C2- Ivanhoe Village Green
and Community Centre

**DA Review –
Final V2**

28 June 2021

LOWER GROUND PLAN

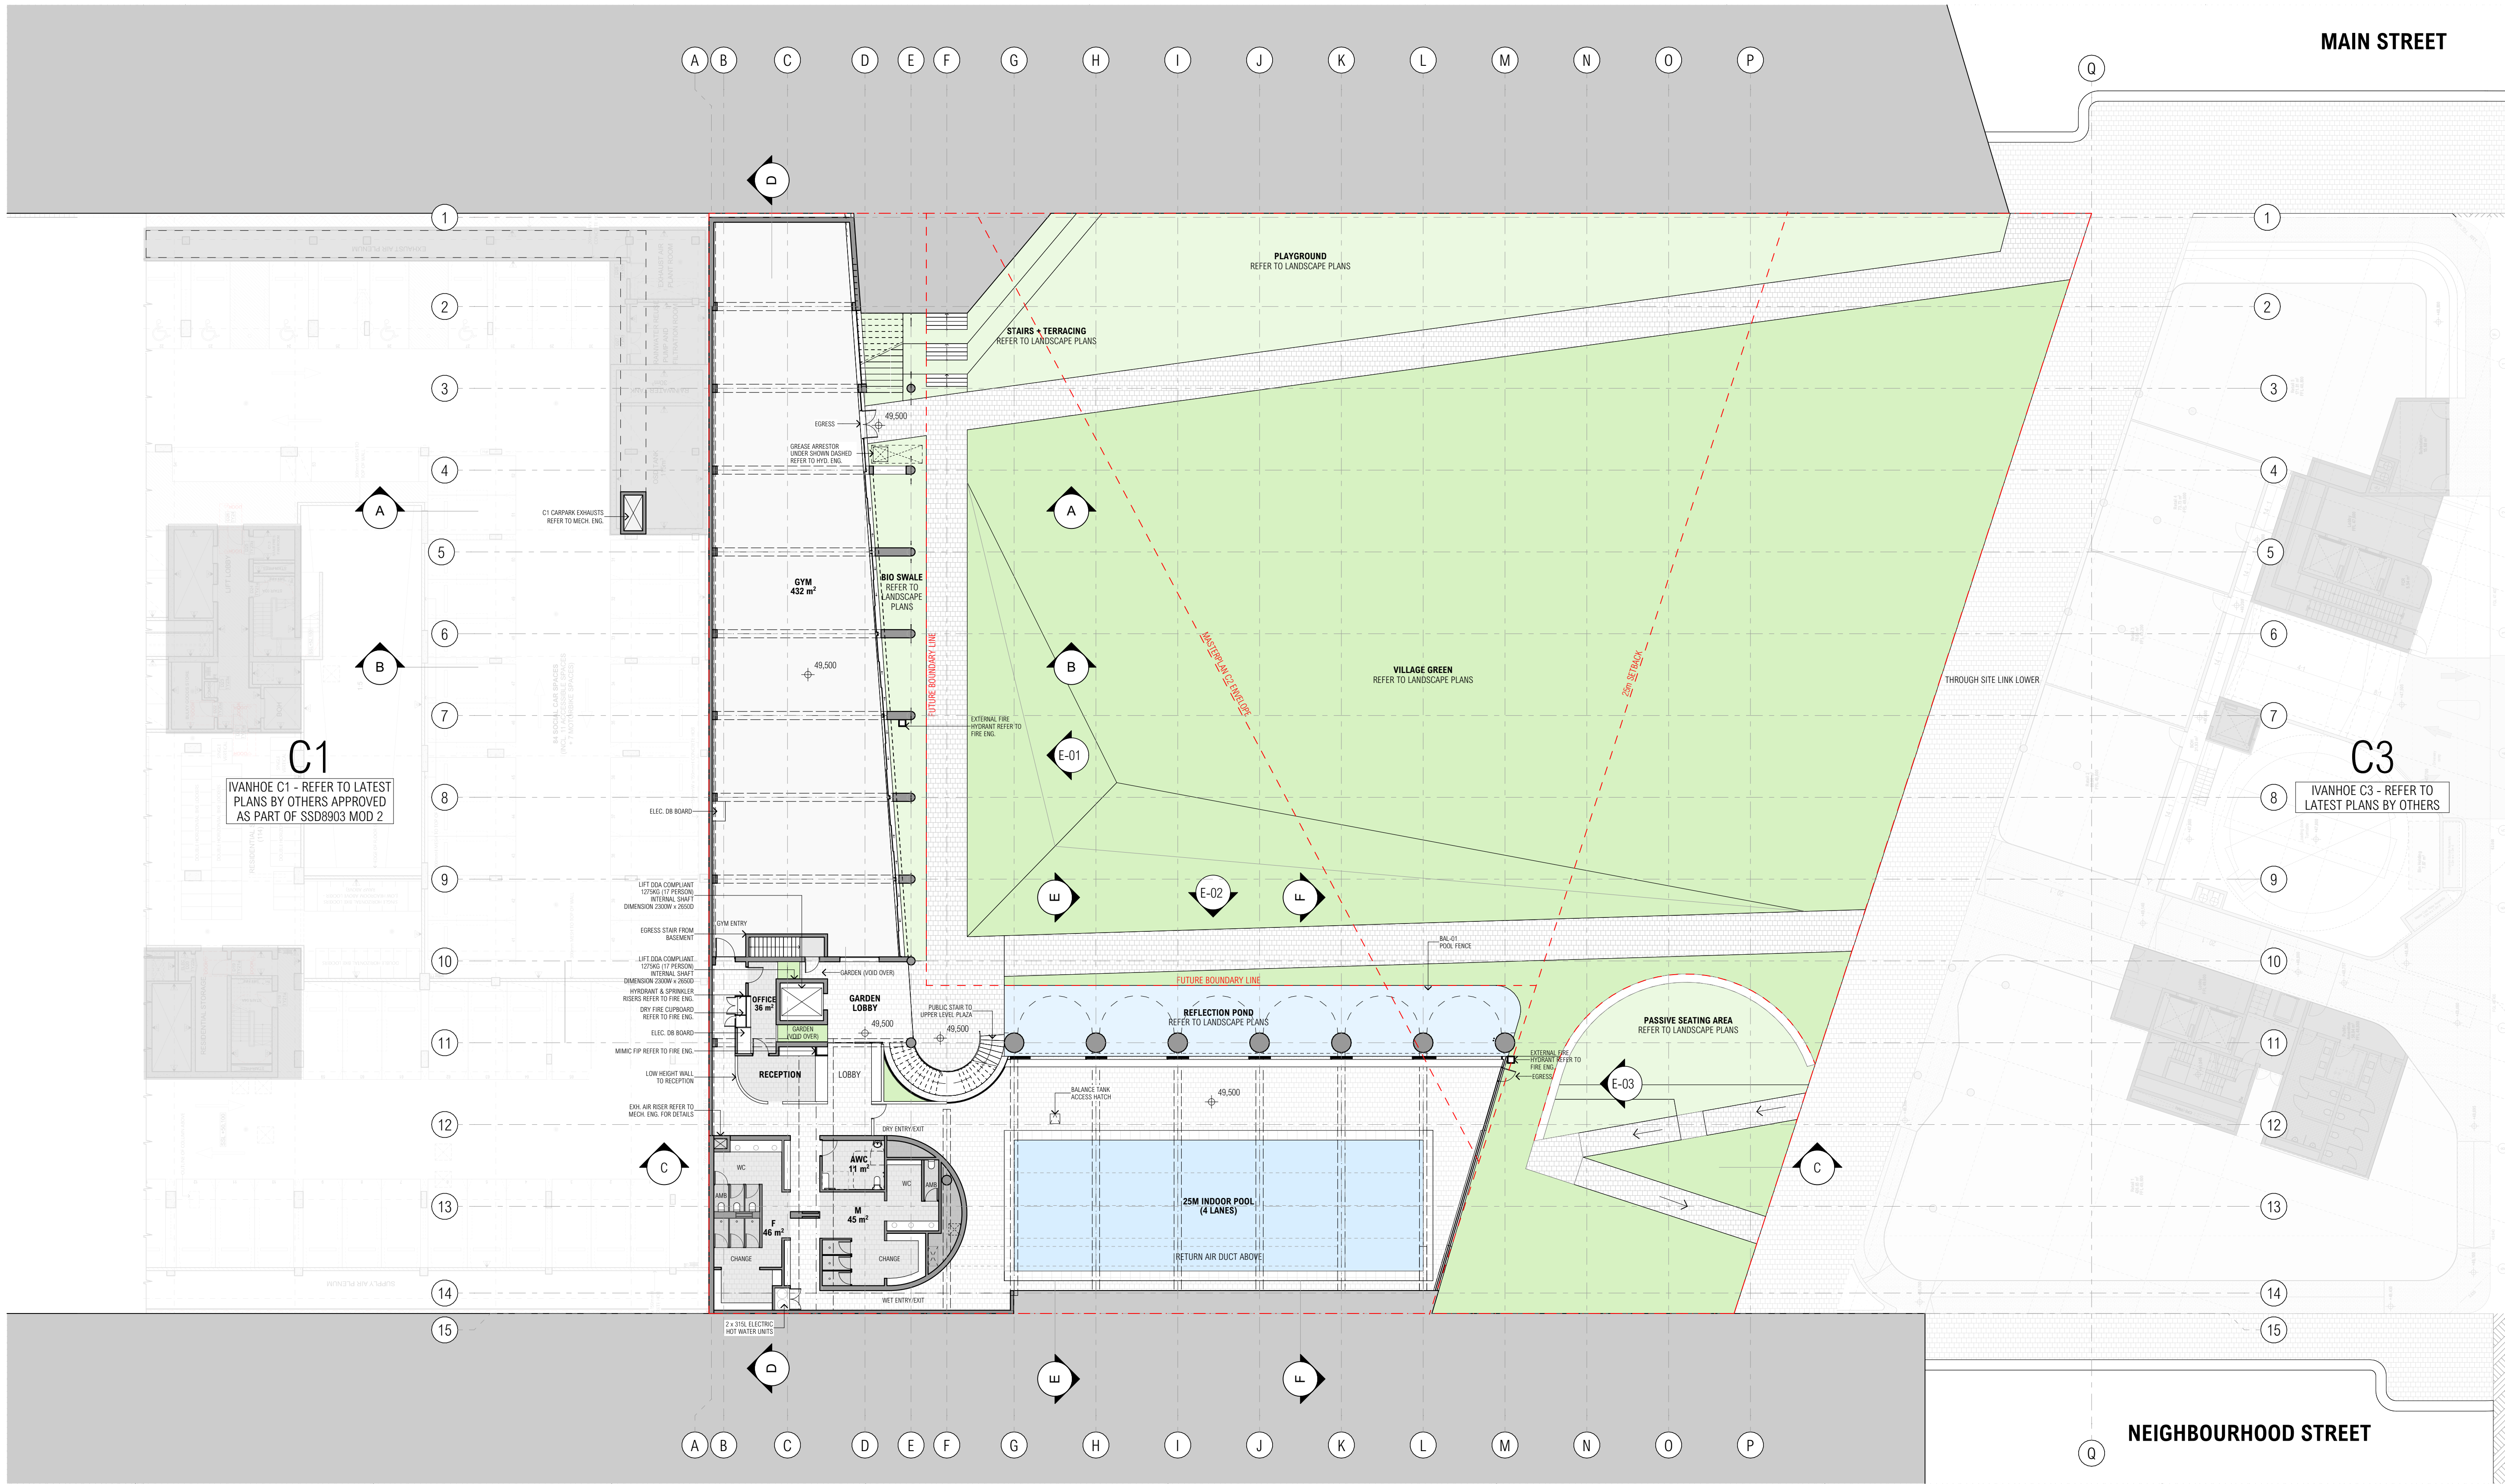
- The included provision of 960mm clear door openings for common-use doors and compliant door circulation (i.e., 1450mm depth and 510mm/ 530mm latch side clearances).
- The provision of a level threshold into the bin room with a 1540 x 2070mm circulation space in front of large bins.
- Confirmation of exempt areas under BCA 3.4 – See MGAC Mark-ups.
- The provision of a 1200mm path of travel in accordance with City of Ryde DCP-section 9.2

- The installation of the stairs 900mm min. from the site boundary for the compliant provision of TGSI's and handrail extension
- The provision of 1200mm deep landings at walkways where gradients are between 1:20 – 1:33.
- The identification of gradients and walkways/ramps within the Passive Seating Area

The provision of 50% alternation between LH and RH transfer Accessible WCs as identified on the attached marked-up drawings

The provision of 960mm wide clear doors to and within the Acc WC as required under City of Ryde DCP- Section 9.2.
